Ribble Valley Borough Council
Housing & Development Control

Your ref: 3/2024/0302
Our ref: D3.2024.0302
Date: 12th June 2024

Application no: **3/2024/0302**

Address: **98 Ribchester Road and land adj 94 Ribchester Road Clayton-Le-Dale
BB1 9HQ**

**A1.2**

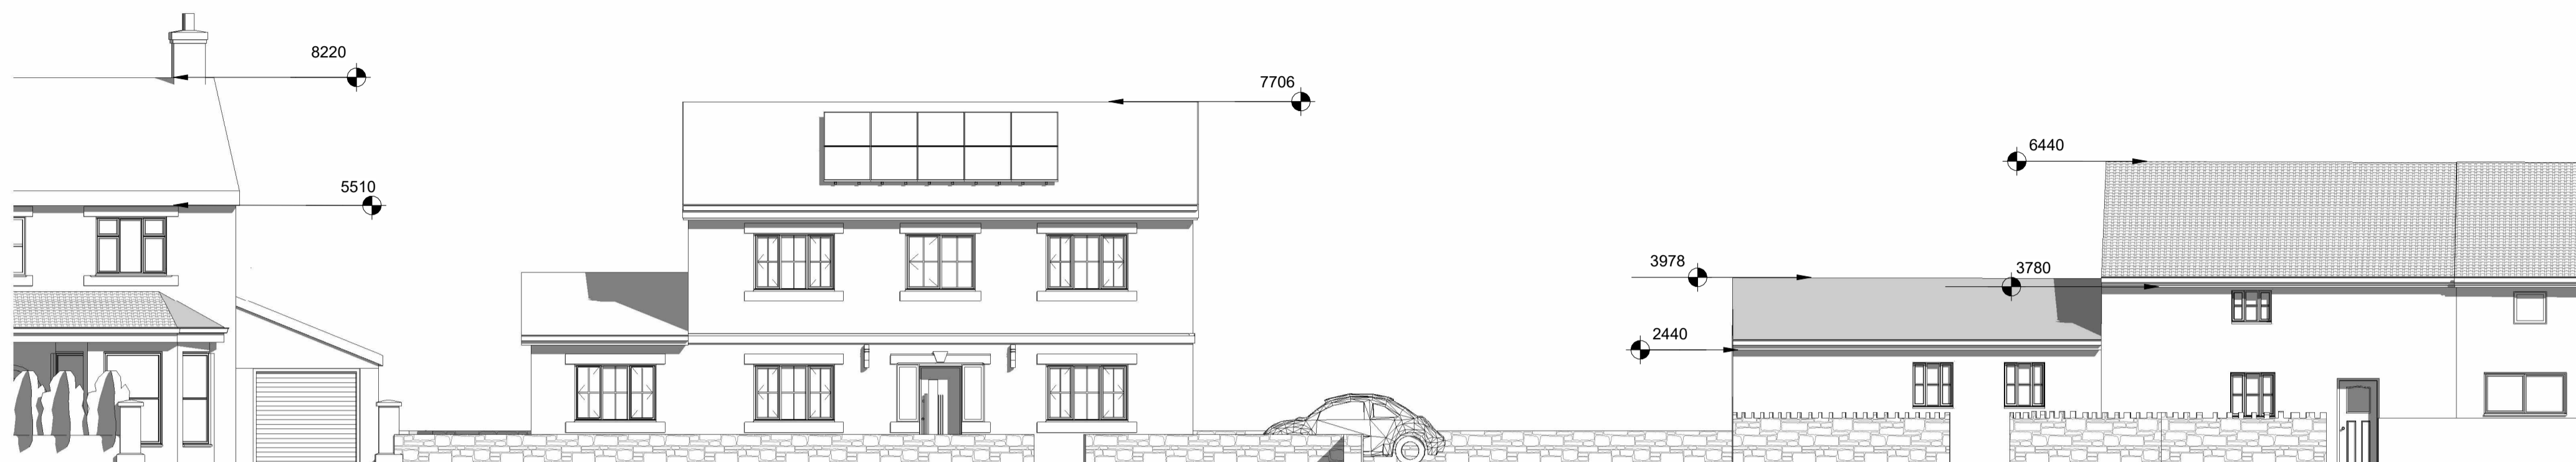
In any case, the LHA have reviewed Peter Hitchen drawing number A1.2 titled "Proposed Site Plan and Context Sheet" and note that the access arrangements complies with the LHAs guidance when serving two dwellings.

However, to ensure that the access provides the adequate visibility, the LHA will condition that visibility splays of 2.4m x 43m are provided in both directions prior to commencement. This is to ensure that adequate visibility is provided. The LHA reminds the Agent that vehicular visibility splays should be drawn, as a maximum, to the carriageway edge.

Following the demolition of the outbuilding, a scheme should also be provided as part of the Section 278 Agreement showing a kerb line/ edge restraint from the proposed access to 94 Ribchester Road.

The LHA have reviewed Peter Hitchen drawing number A1.2 titled "Proposed Site Plan and Context Sheet" and are aware that the proposed parking arrangements complies with the LHA parking guidance as defined within the Joint Lancashire Structure Plan.

The LHA will condition that the proposed dwelling provides a minimum of one electric vehicle charging point and the proposed garage provides a minimum of 2 cycle stands.

3. No part of the development hereby permitted shall be occupied until such time as the access arrangements shown on Peter Hitchen drawing number A1.2 have been implemented in full.

4. No part of the development hereby permitted shall be occupied until such time as vehicular visibility splays of 2.4 metres by 43 metres have been provided at the site access. These shall thereafter be permanently maintained with nothing within those splays higher than 1 metres above the level of the adjacent footway/verge/highway.

7. The development hereby permitted shall not be occupied until such time as the parking and turning facilities have been implemented in accordance with Peter Hitchen drawing number A1.2. Thereafter the onsite parking provision shall be so maintained in perpetuity.
